RE: RESPONSE TO SUBMISSIONS - LANDSCAPE

The following letter provides response to all submissions received that are relevant to the proposed landscape design.

Director, Turf Design Studio

Zonal Plan

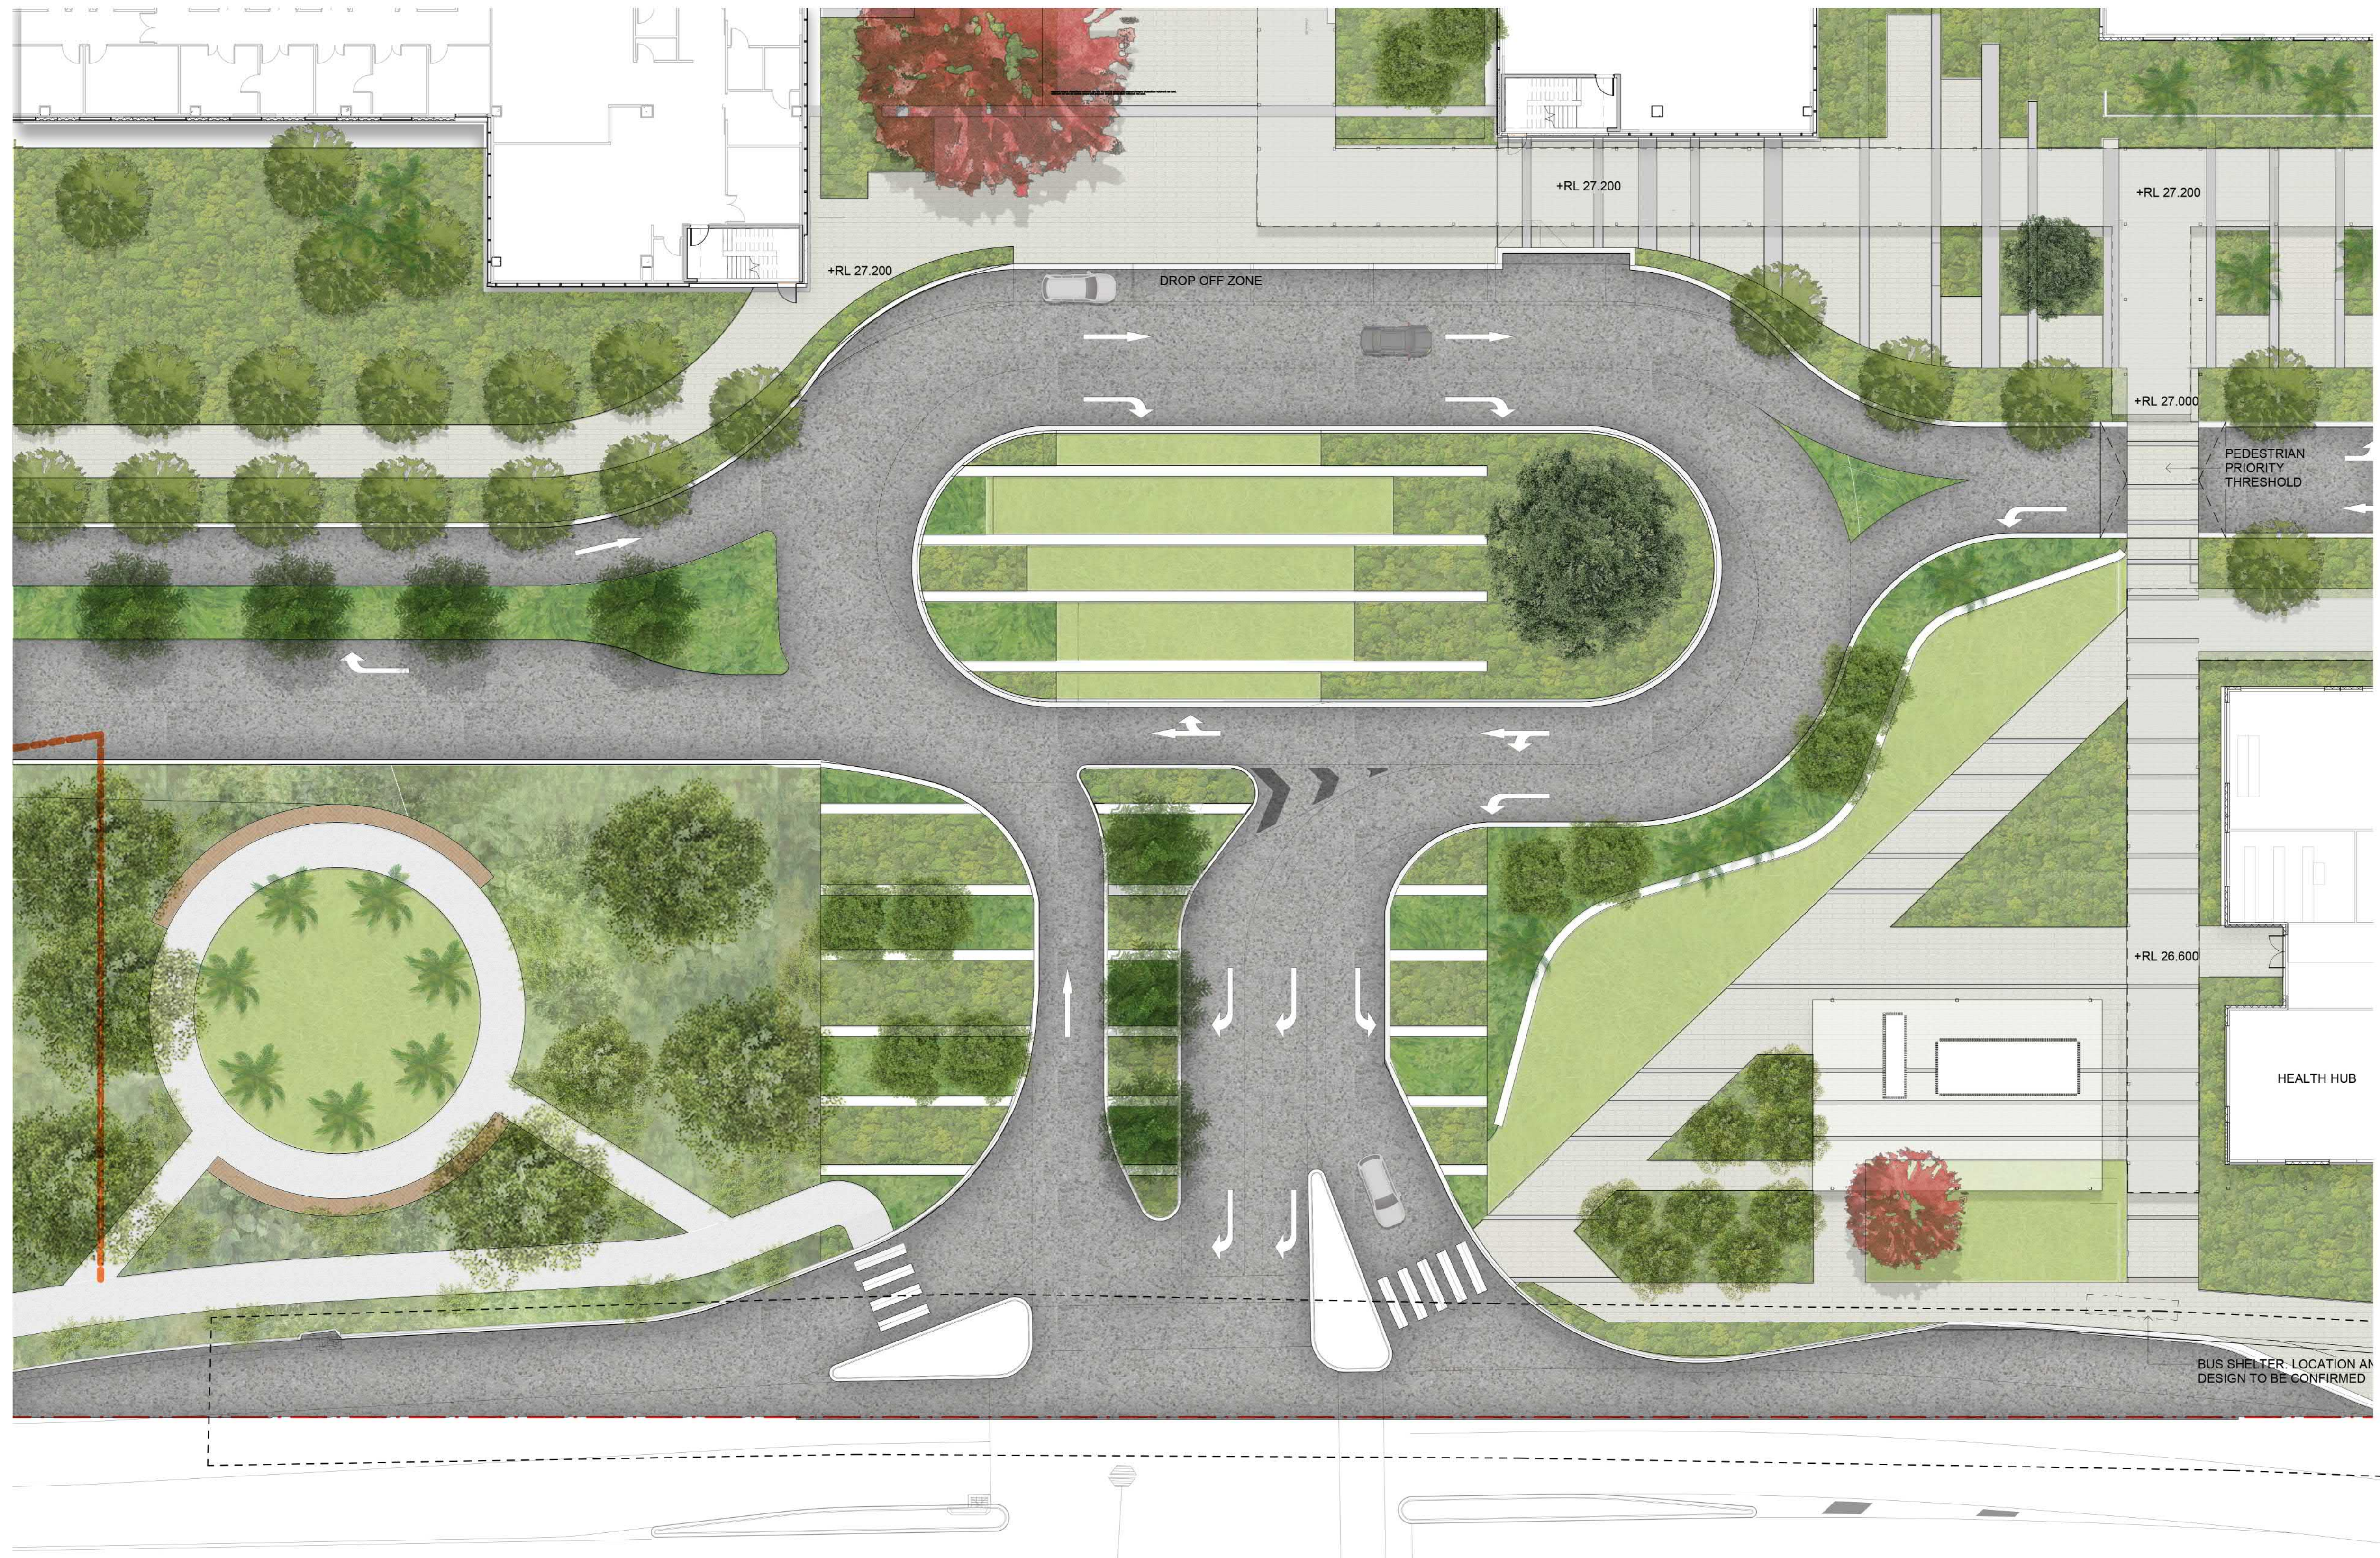
<i>4b. The turf report should provide details of how many koala food trees will be planted and the locations of these plantings</i>	A total of 42 koala food trees will be planted, evenly distributed within landscape zones 7 and 10. Refer BCD4c below for further details, and “Koala Food Trees Markup” plan attached.
<i>4c. Consideration be given to planting koala food trees in the south west corner (area 7 in the landscape zonal plan (LZP)) and lawn area</i>	Planting of Koala food trees has been considered in these areas, and the following approach is proposed...

<p>76. Condition B7 states “The site plan and the landscape masterplan for the Stage 2 application must include the following as identified in the approved Landscape Zonal Plan prepared by Turf Design Studio dated 03/05/2019:</p> <p>(i) details of ‘Koala food trees’ to be planted in proximity to the identified potential koala habitat locations in vegetation Zone 6 of the Biodiversity Development Assessment Report prepared by Greencap dated January 2019.”</p>	<p>(as mentioned in the comments).</p> <p>A total of 20 koala food trees are incorporated into the adjacent Zone 10 planting area (refer landscape zonal plan), spacing in accordance with canopy separation requirements for APZ.</p> <p>In addition to this, 22 Koala food trees are proposed in Zone 7, adjacent to Zone 10.</p> <p>For specific details of proposed locations for Koala food trees, please refer BCD 4c above, and “Koala Food Trees Markup” plan attached.</p>

<p>77. This condition is not clearly addressed. Koala food trees appear in broad planting species lists, but the Landscape Plans and BMP do not provide specific detail or direction on the use of these trees in the location required by this condition. It is suggested that the relevant plans are revised to provide this detail.</p>	<p>For specific details of proposed locations for Koala food trees, please refer BCD 4c above, and “Koala Food Trees Markup” plan attached.</p>

A total of 22 koala food trees (11 of each species) will be planted in locations as shown on the landscape zonal plan.

A total of 20 Koala food trees (an even mix of available recommended species, evenly distributed throughout the zone) will be integrated into the existing tree planting general arrangement, in accordance with the above canopy separation requirements. Refer "Koala Food Trees Markup" plan attached.
